August 5, 2011

Re: 120 Baxter Boulevard – 111 B006 – R-5 – Permit #2011-07-1709  
17 Codman Street – 129 G011 – R-3 – Permit #2011-07-1712  
209 Stevens Avenue - 177 I010 – R-5 – Permit #2011-07-1708

Our office is in receipt of your three building permits, one for each property listed above. At this point the permits for 120 Baxter Boulevard and 17 Codman are on hold, and the permit for 209 Stevens Avenue is denied.

1 BUILDING SECTION
 SCALE: 1/2" = 1'-0"
 0 12" 2' 4'

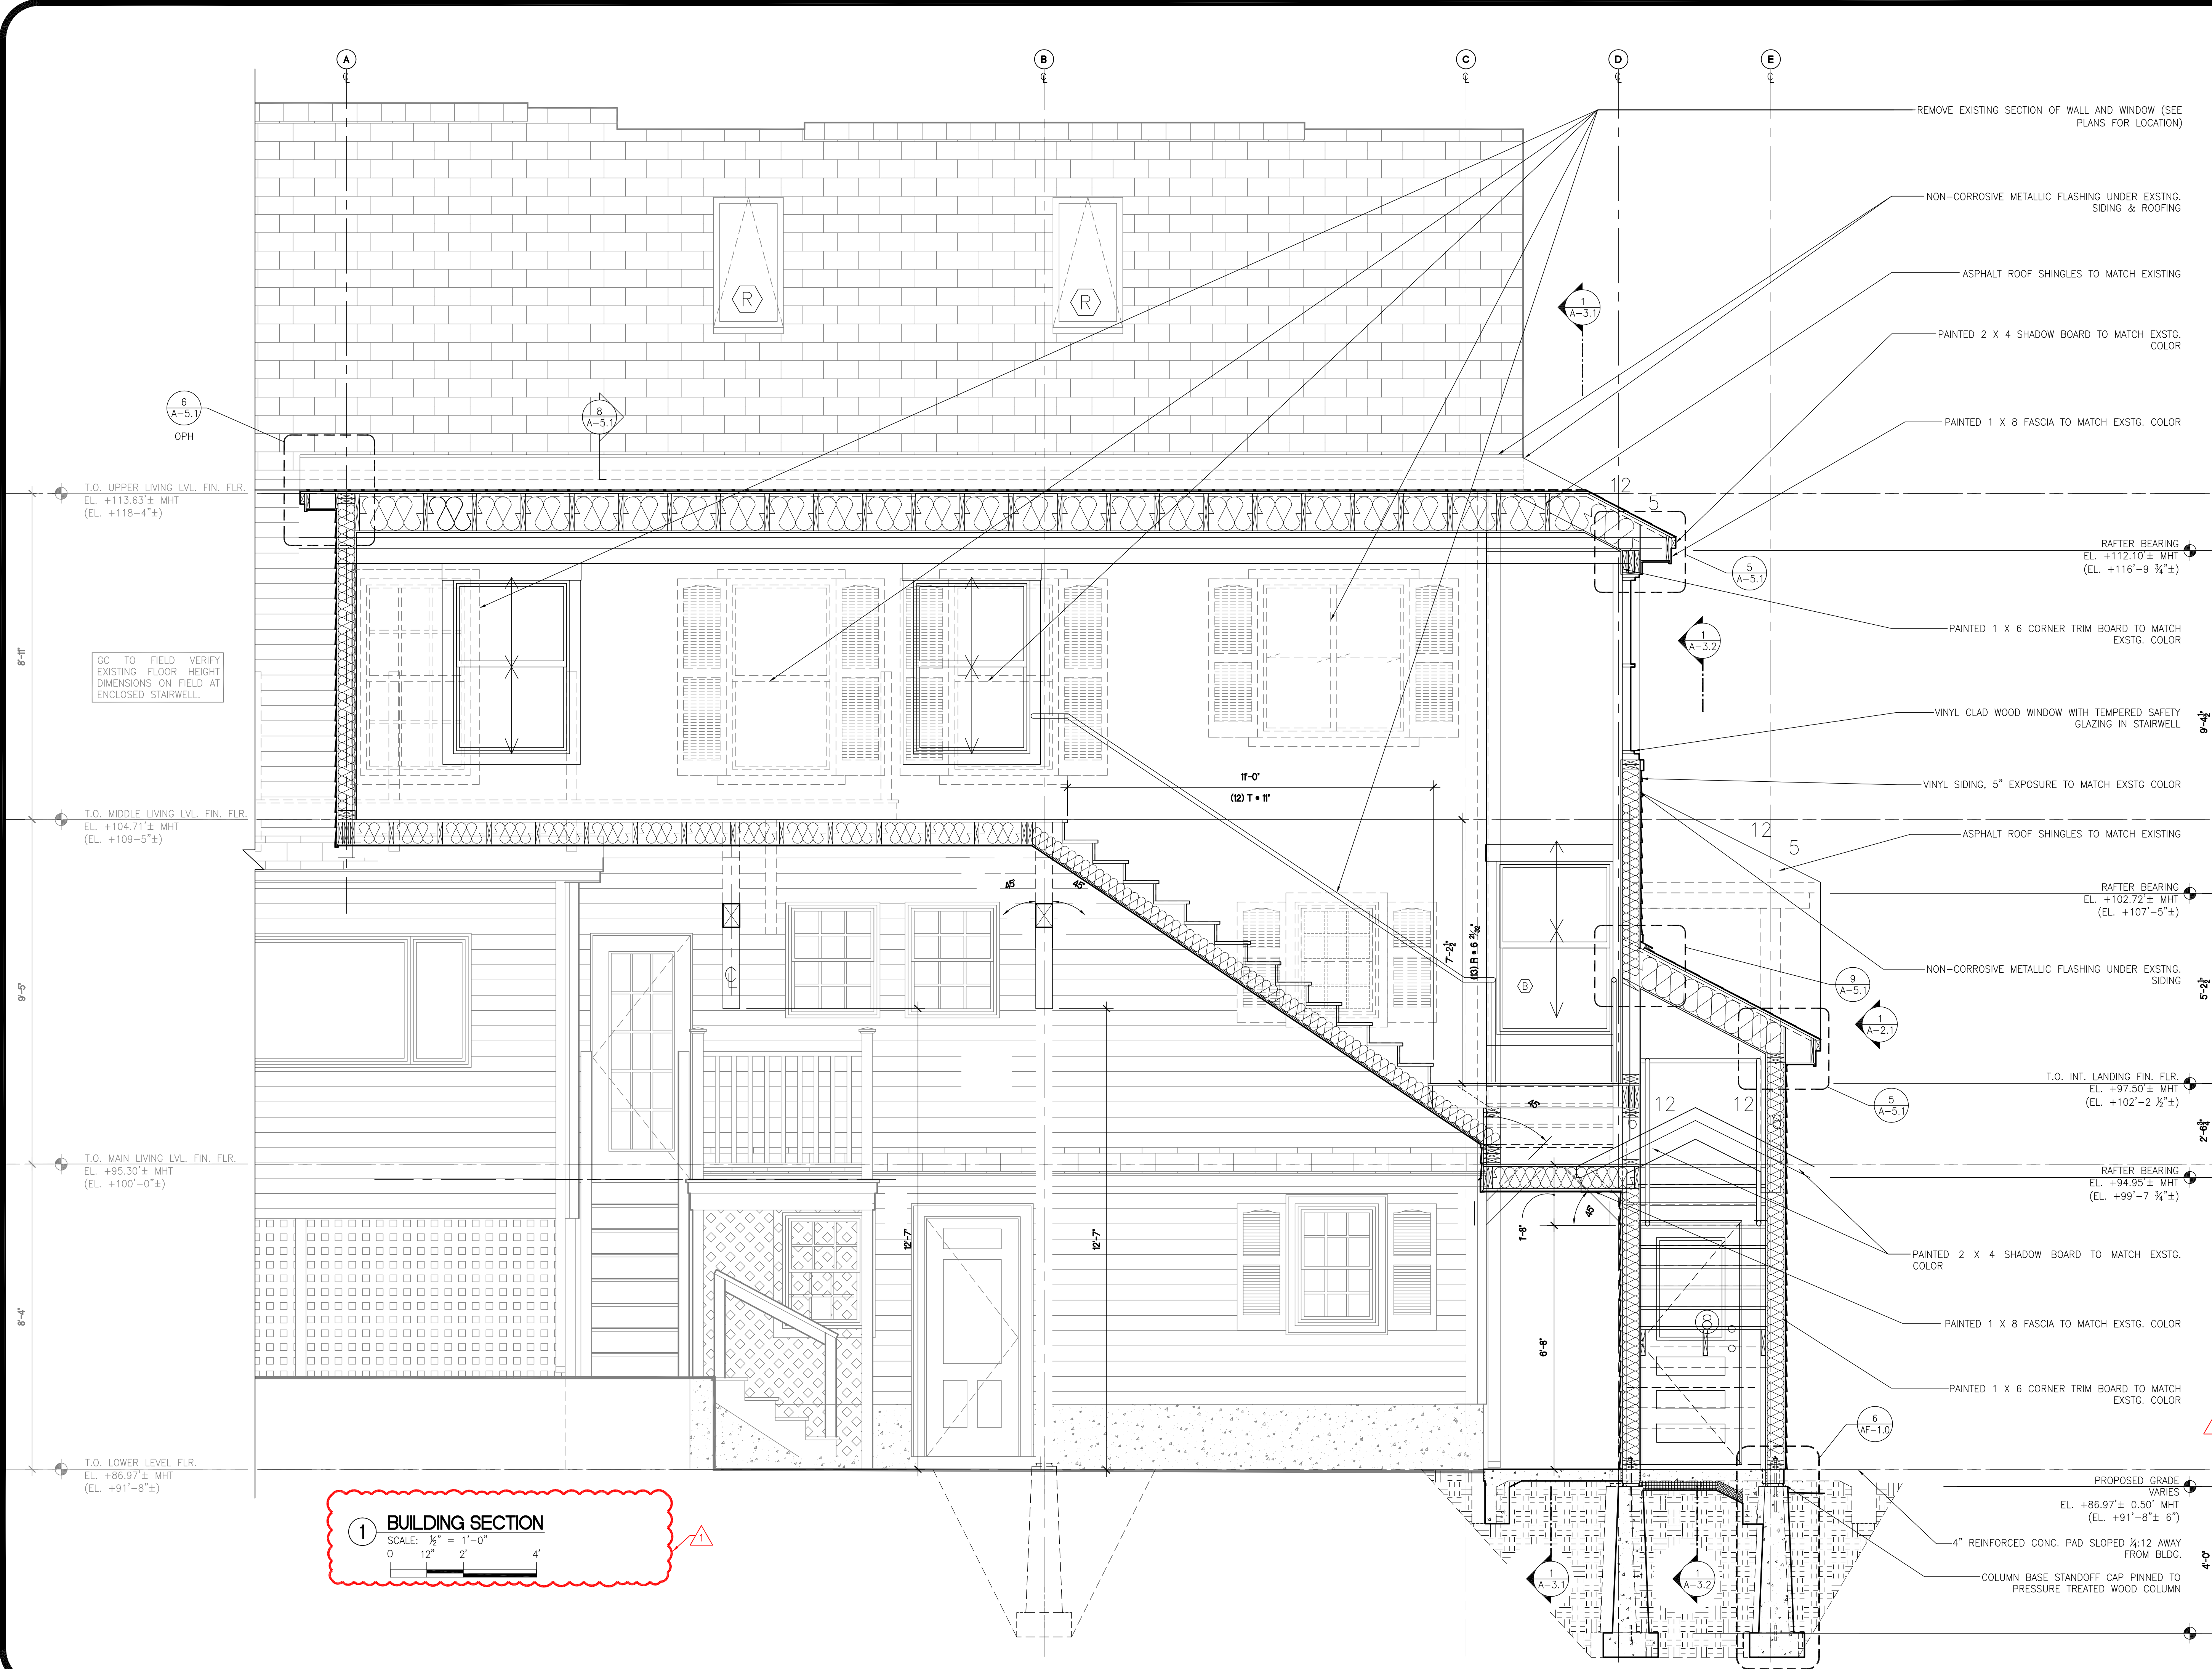
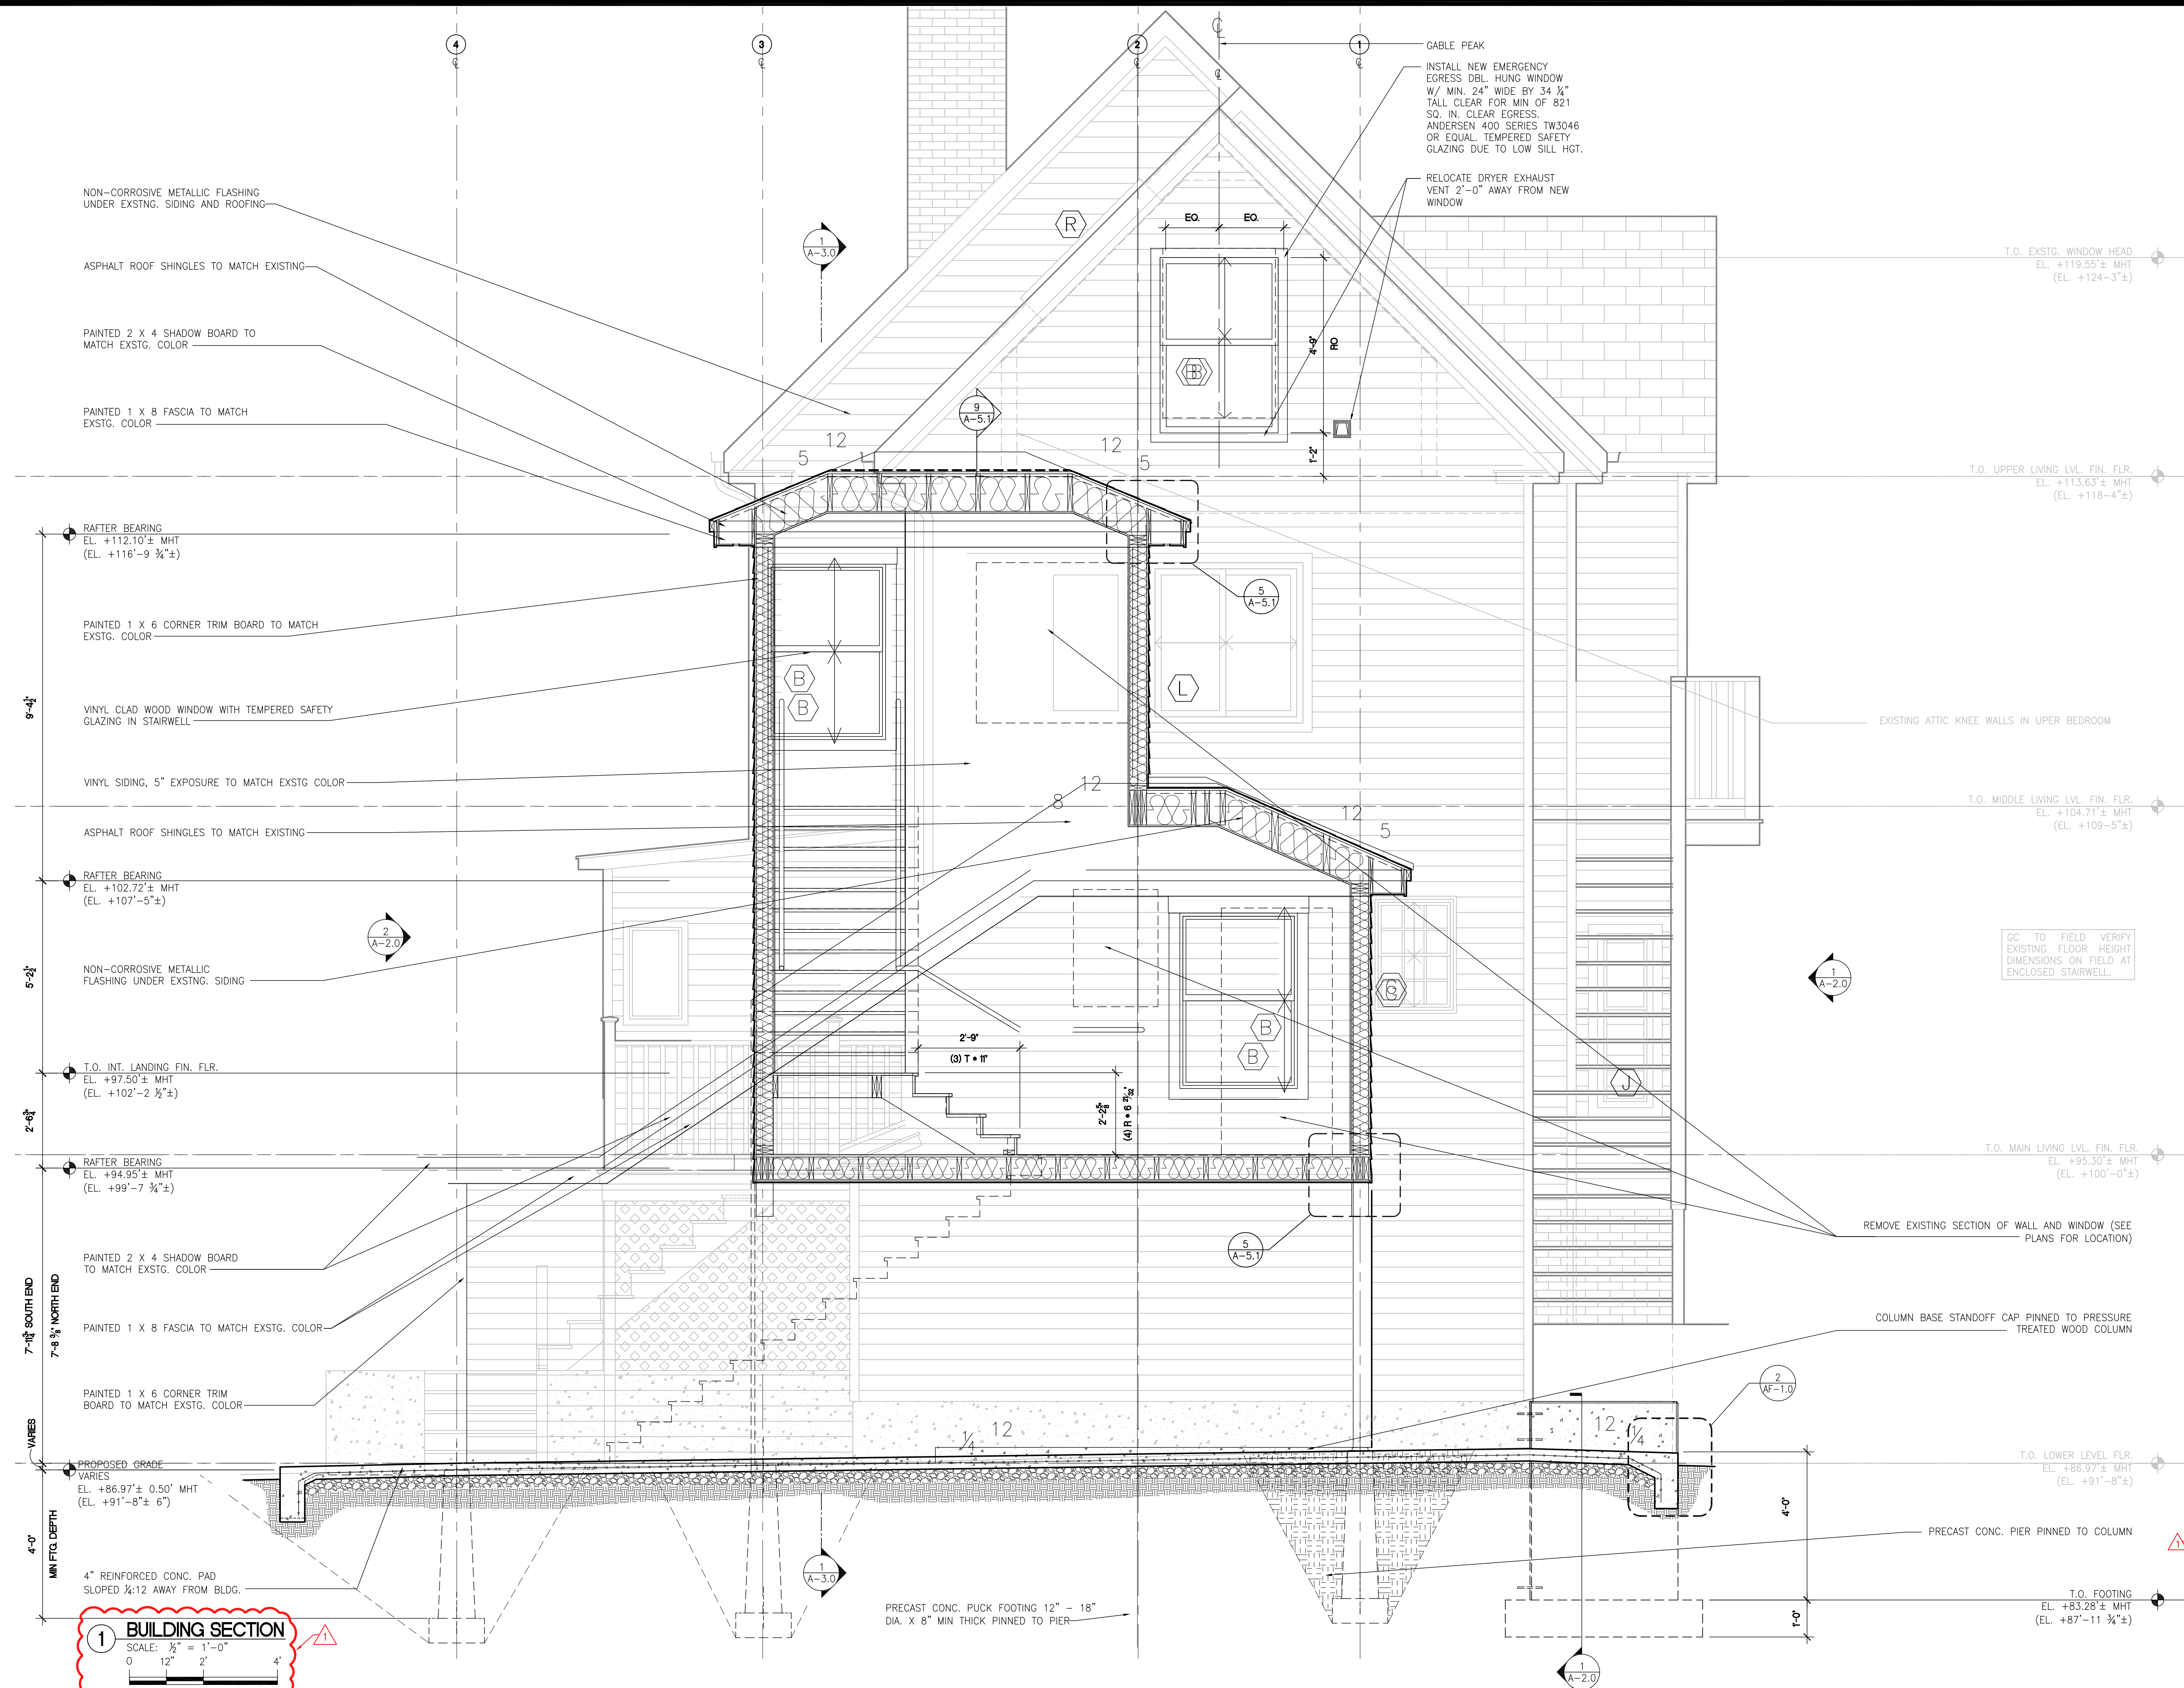
This permit is denied. Part of the application is to build an exterior stair from the second floor to the ground as a means of egress. This is a four family dwelling in the R-5 residential zone. Section 14-117(a)(2)(c) states that "no open outside stairways or fire escapes above the ground floor shall be constructed.". If a second means of egress is required, it must be constructed as a completely enclosed structure. You need to submit revised plans that show an enclosed stair that meets all the zoning requirements.
